**From:** [Brenda Larsen](#)  
**To:** [Jeff Watson](#)  
**Subject:** RE: BL-10-00041 BPA  
**Date:** Tuesday, November 30, 2010 3:53:44 PM

Re: BPA (BL-10-00041)

BOUNDRY LINE ADJUSTMENT
 PREPARED FOR
HORIZON WIND ENERGY/BPA
 SECTION 15, T.19N., R.17E., W.M.

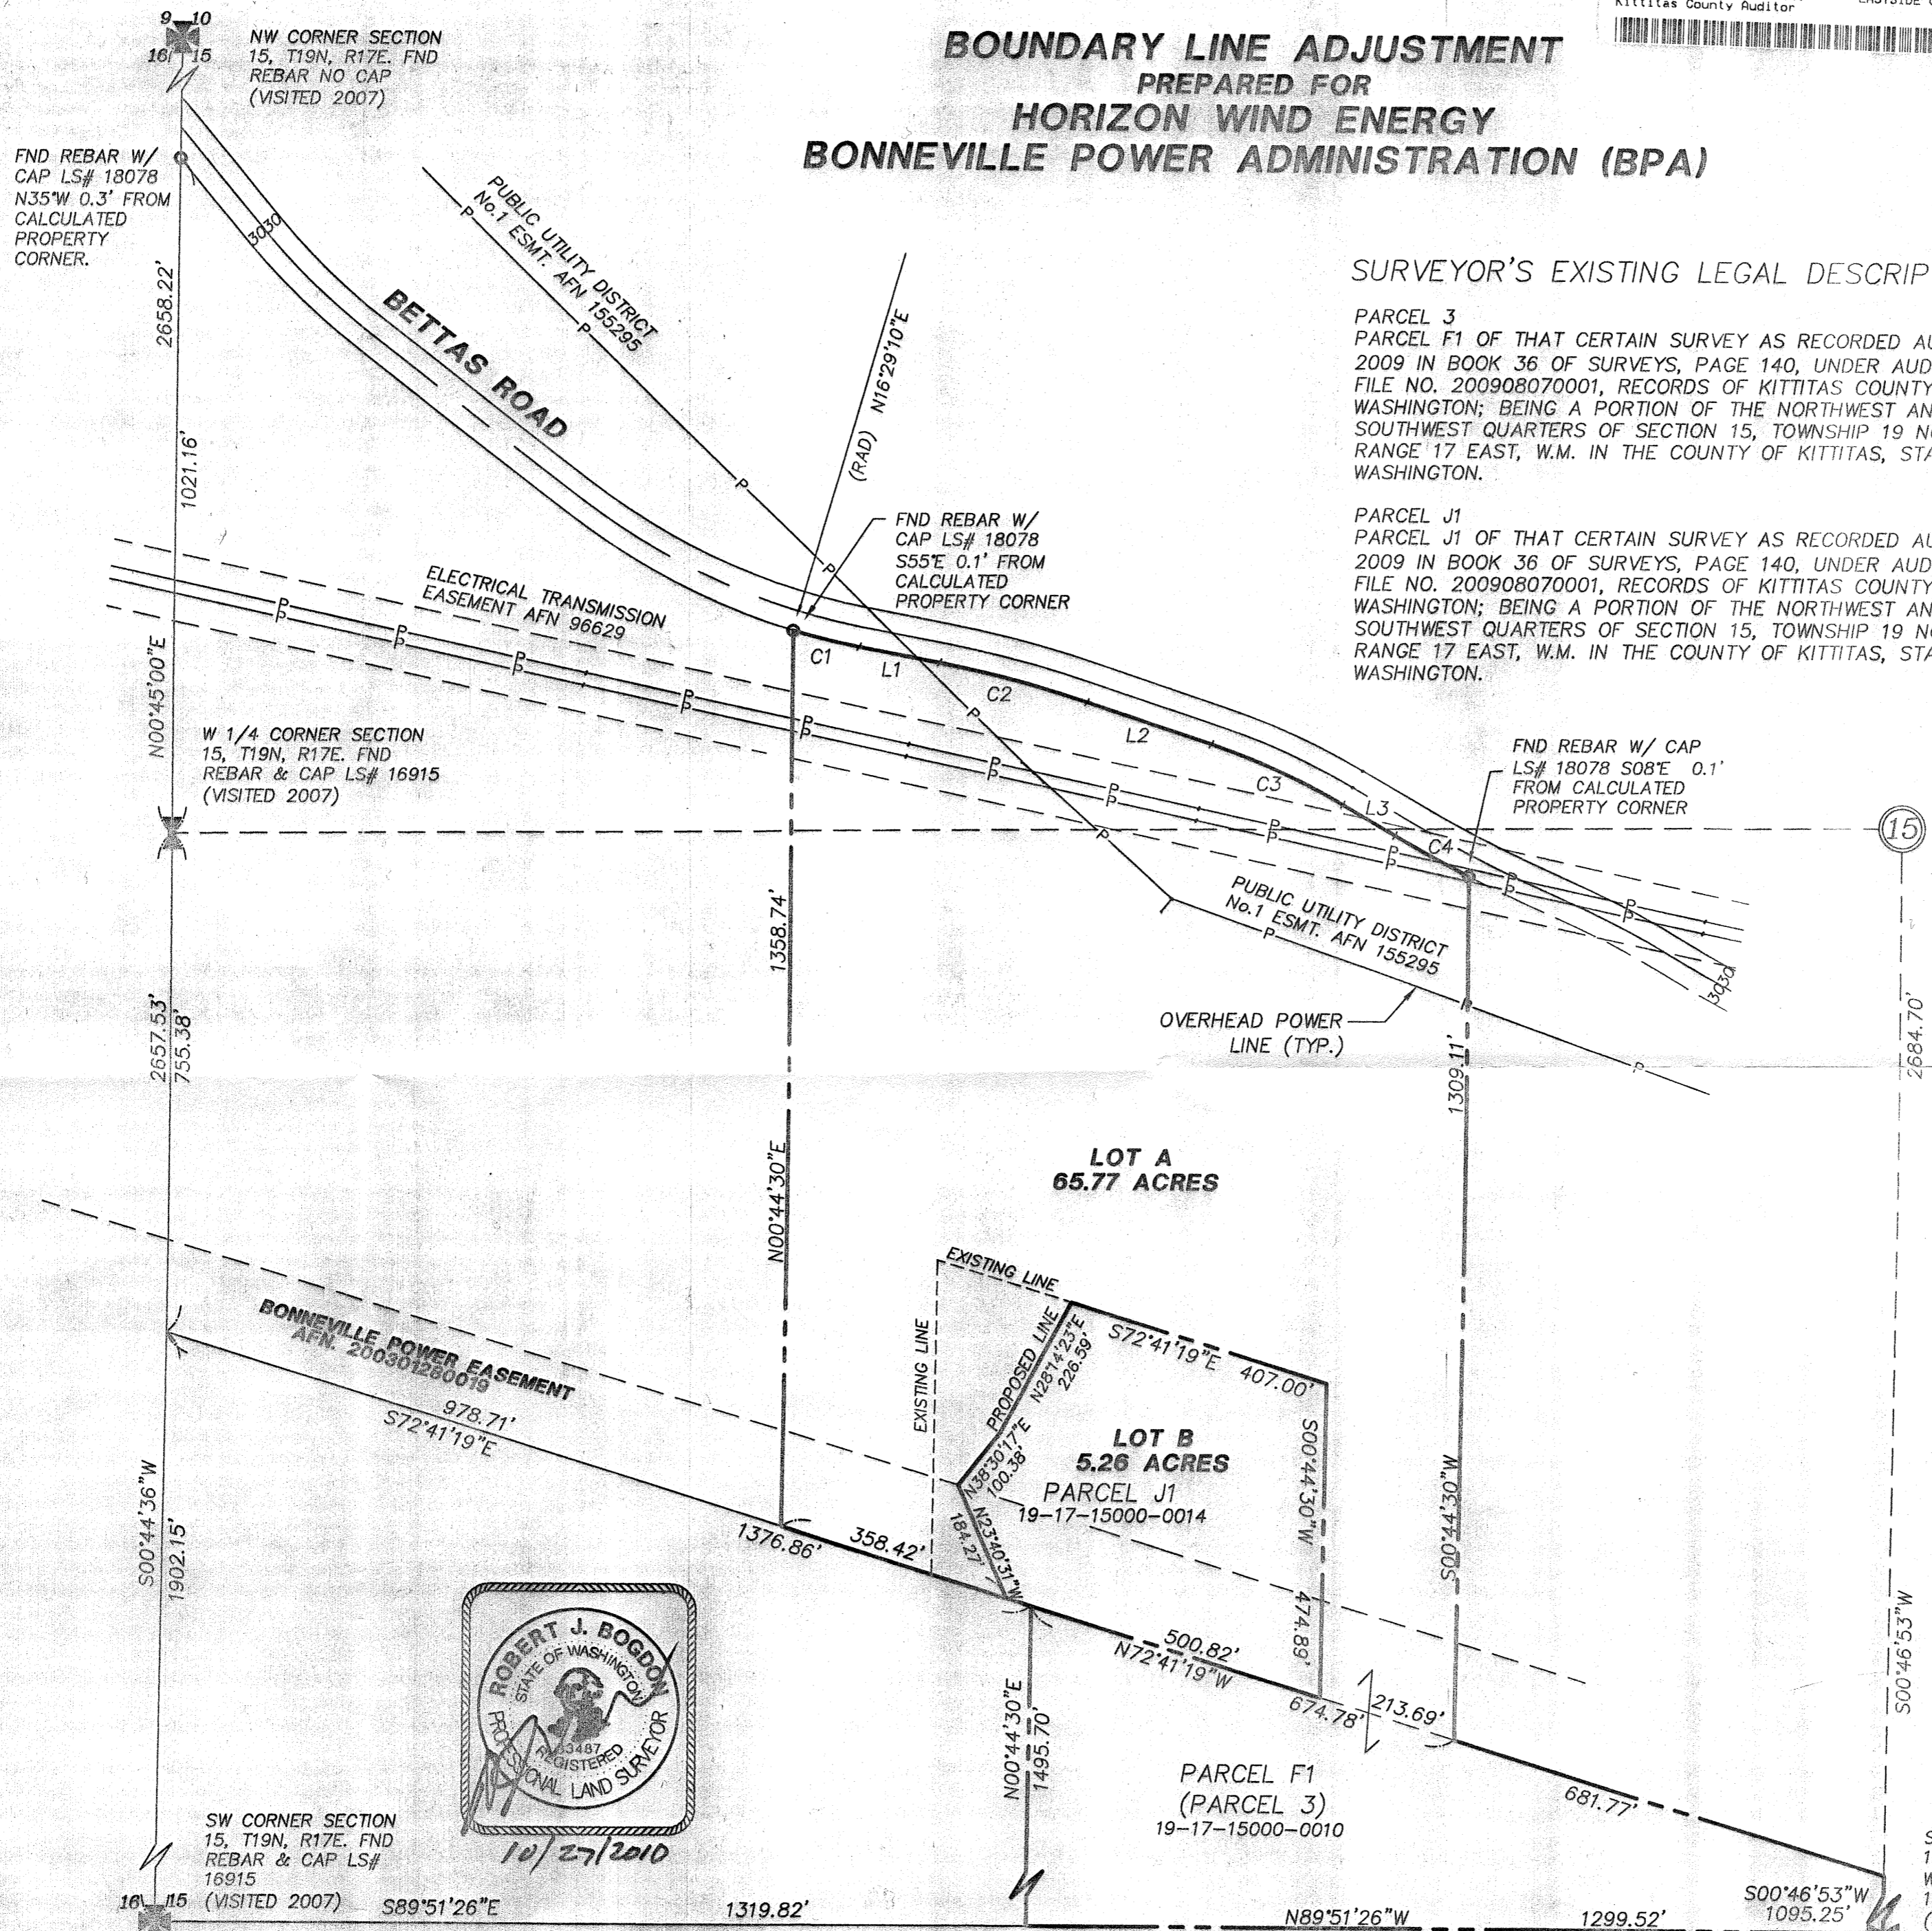
- Ensure that boundary line adjustments do not infringe upon existing structures, to include propane tanks, etc.
- Creation of any additional roads or access must comply with the International Fire Code.
- All future development must comply with the International Fire Code.
